Re: Railway works and all works necessary to eliminate and, where necessary, upgrade seven numbered level crossings and carry out all associated and ancillary works along a 24-kilometre section of the Dublin to Cork Railway Line.
Fantstown, Thomastown, Ballyhay, Newtown, Ballycoskery (Ballyhea Village), Shinanagh and Buttevant, Co. Cork and Co. Limerick.

**Submission to Bord Pleanála from
Committee for Ballyhea Community Hall**

Ref. N. NA04.310286

The above Committee makes this submission to Bord Pleanála concerning a proposal to close level crossing XC 212 at Ballycoskery (Ballyhea Village), to replace it with a flyover of excessive proportions, built in the idiom of a dated brutalism, and to realign the road network leading to and coming from the flyover.

Figure 2.11: XC212 Ballycoskery Proposed Alignment

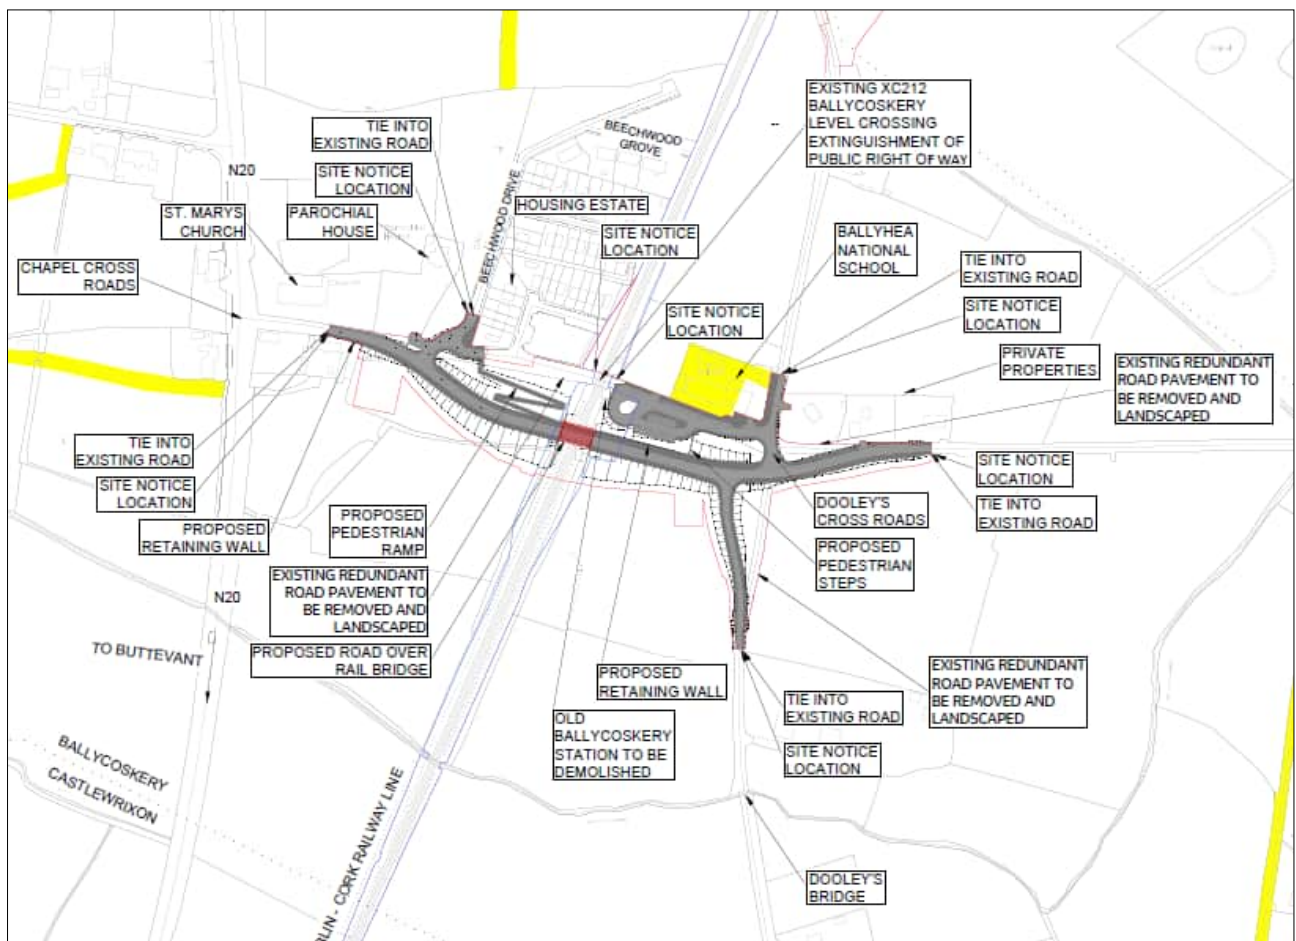
The documentation on which the proposed development relies makes no effort to conceal the massive brutalism of the proposed flyover which is euphemistically described as 'utilitarian'. Its incongruous lack of proportionality with a small rural village suggests disaster levels on a par with Sam Stephenson's Central Bank of Ireland building on Dame Street in Dublin, or the Dublin Corporation Offices on Wood Quay, or the (mercifully demolished) ESB headquarters on Fitzwilliam's Street. Theoretically the proposed development might be classified as a recrudescence of 'the recidivist views of a handful of unreconstructed Functionalists' blinkered to the aesthetics of form, matter, proportion and materials.

The use of concrete blocks in a context of Victorian stone-masonry, undressed poured concrete, light pollution, stainless-steel, the removal of vegetation and natural habitat, and a height level twice the roofline of the Community Hall characterize an approach that has forgotten nothing and learned nothing from a catastrophic and deviant experiment, long abandoned in more cultured milieus.

Figure 4-9 XC212 Alternative options

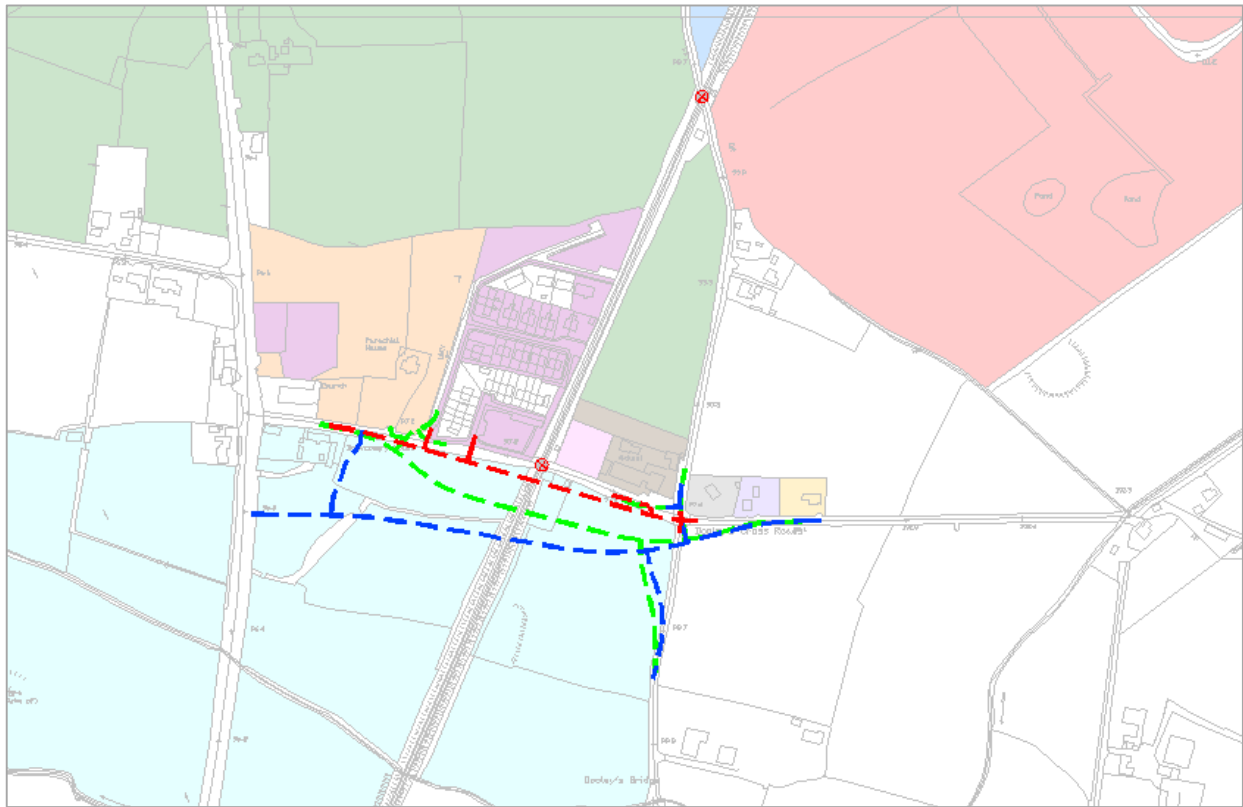
1. A full feasibility study and analysis was not undertaken for XC212 at Ballycoskery as all potential options for a new crossing facility were not reviewed;
